City of Albuquerque Stormwater Construction Site Inspection Report

| Project Name: | Montecito Vistas | | | | | |
| Site Contact Name & Agency | Eric Crum / Kevin Patton | ESC File No. | D09E005 | | | |
| Inspection Date: | 03/14/19 | Start/End Time: | 0830/1000hrs | | | |

CITY OF ALBUQUERQUE PUBLIC WORKS DEPARTMENT	
MONTECITO VISTAS EROSION CONTROL PLAN			
Design Review Committee	City Engineer Approval	Mo./Day/Yr.	Mo./Day/Yr.
City Project No. 763983		Sheet 1 Of 2	
		Zone Map No. D-09	
		City Project No. 763983	
		Zone Map No. D-09

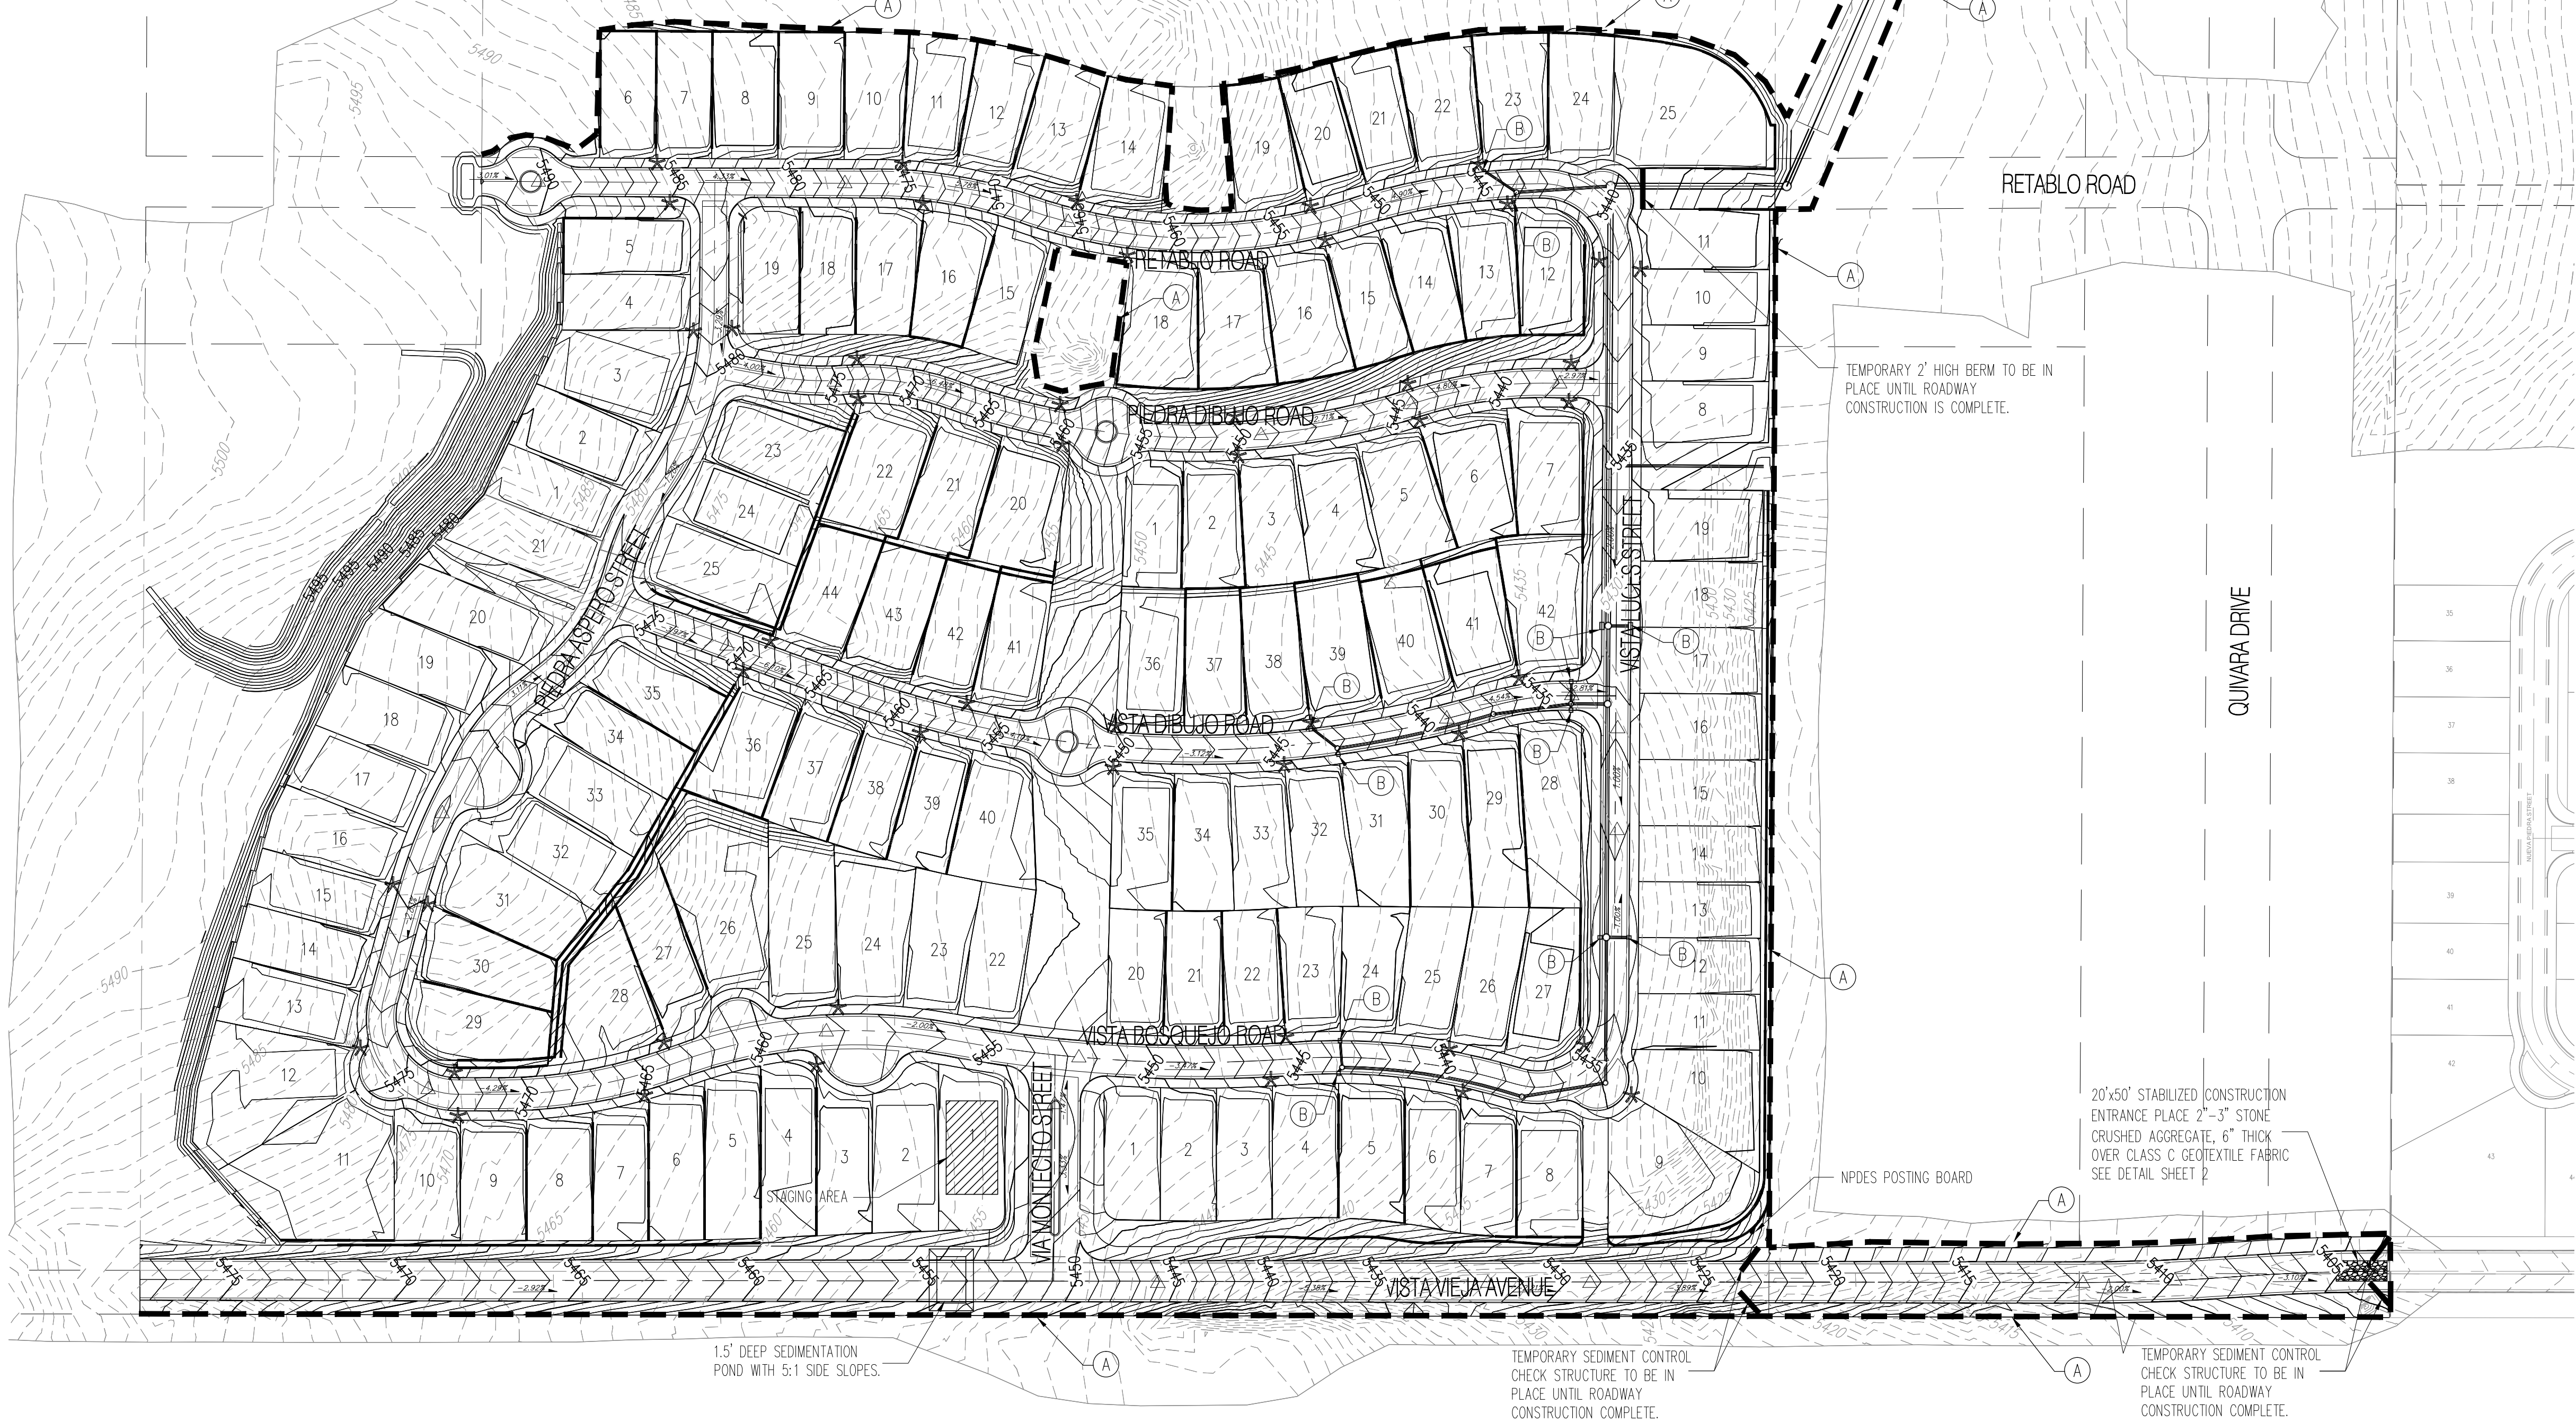
| CGP Section | BMP / Activity | Maintenance or Corrective Action Required | Location and Notes |
|-------------|--|---|--|
| 2.2.3 | Sediment control along any perimeter | x | Track out pad Retablo west end |
| 2.2.3 | Sediment control along any perimeter | x | North side of site - silt fence maintenance |
| 2.2.3 | Sediment control along any perimeter | x | curb cuts and curb BMP's- depress or provide BMP |
| 2.2.3 | Sediment control along any perimeter | x | Re-establish silt fence at outfall pipe |

| 2.2.5 | Manage stock piles | x | Stock piles at back of curb require BMP |
| 2.2.10 | Protect storm drain inlets | x | clean all inlet. Maintenance |
| 2.2.10 | Protect storm drain inlets | x | out fall to the NE clean trash |
| 2.2.14 | Stabilize exposed portions of the site | x | clean sediment in streets |
| 2.3.4 | Washing applicators used for paint, stucco, concrete, etc. | x | Maintenance on concrete washout required |

Maintenance or corrective actions are to be completed within seven (7) days.
